TO: Randy Foulke
PROJECT #: 25-1093-A
PAGE: 1 of 2
DATE: November 4, 2025
LOCATION: 203 A D Hall, Sanford NC
PLAN REF: Foulke Residence by South Designs
Project# 25-1093

THE FOLLOWING CHANGE(S) OR PROPOSED CHANGE(S) LISTED BELOW ARE
DEVIATIONS OR CLARIFICATIONS FOR THE ABOVE REFERENCED PLANS:

FOUNDATION STRUCTURAL PLAN

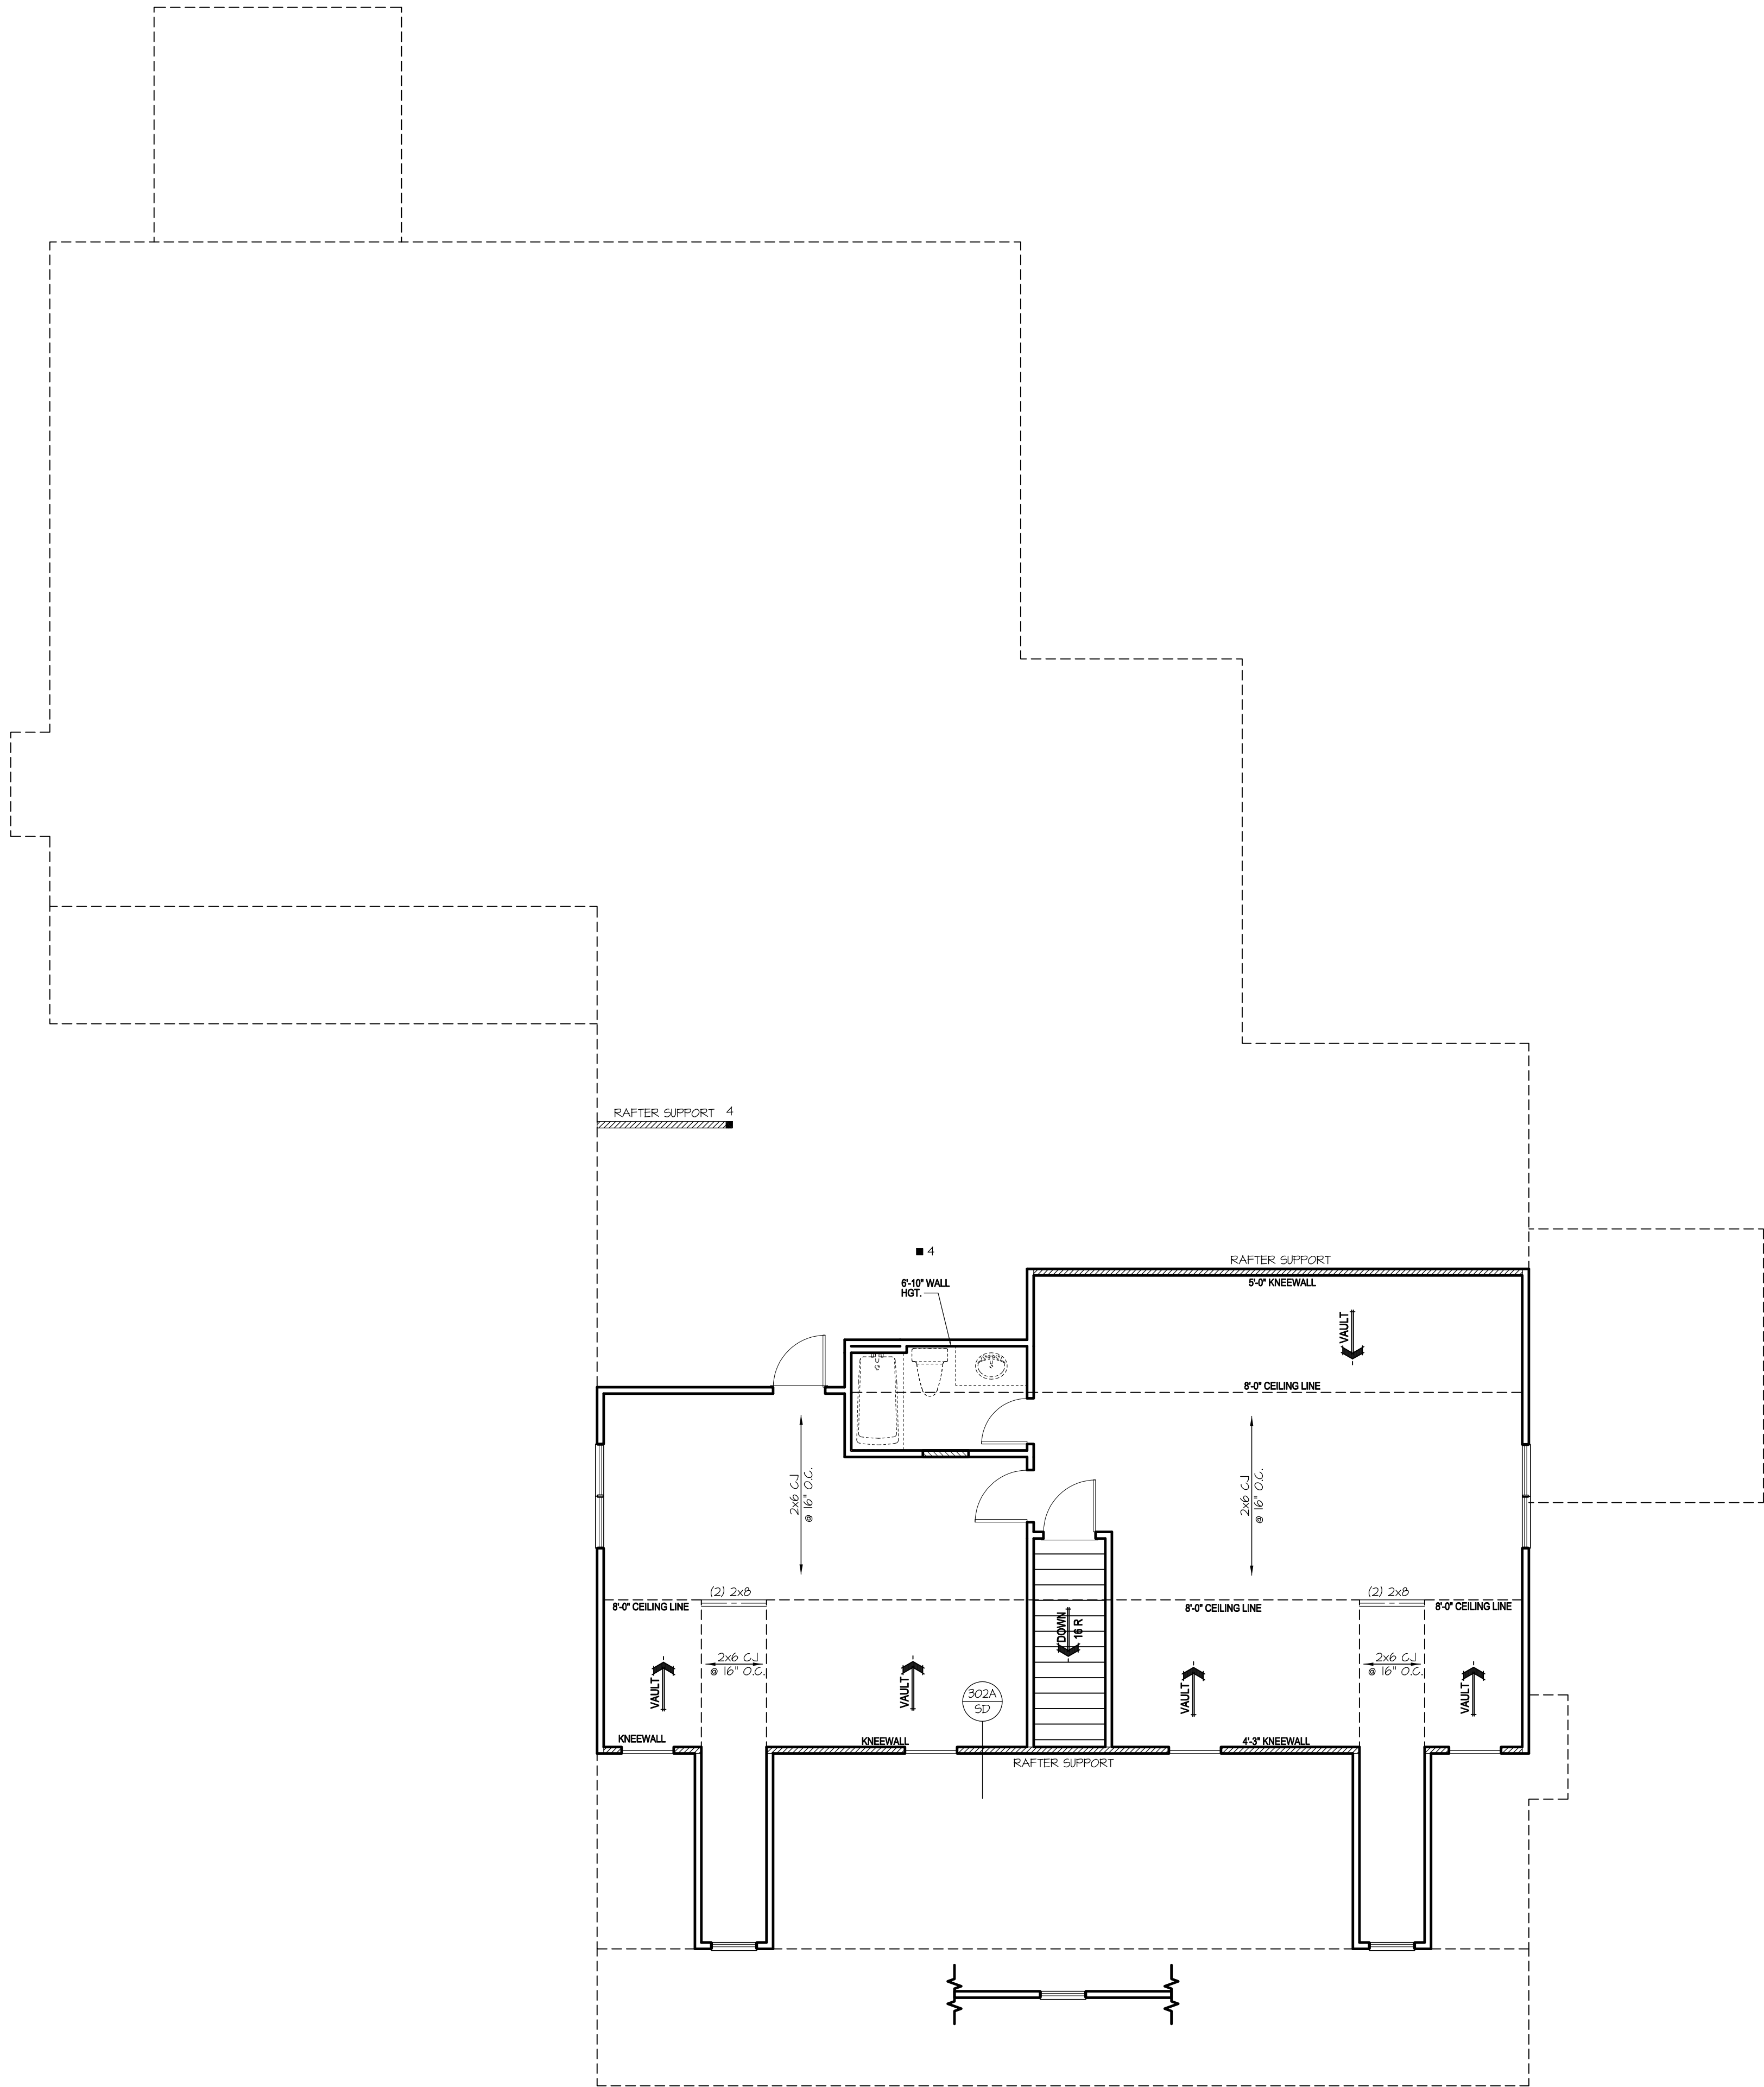
Footing Projections: Per information collected on October 30th, 2025 during a site observation the three areas marked in the image below did not have adequate projection and require additional footing.

Response: Additional concrete shall be added in the marked locations according to detail 124C-SD included below.

124C
SD

ADDITIONAL FOOTING (AT INSUFFICIENT PROJECTION)
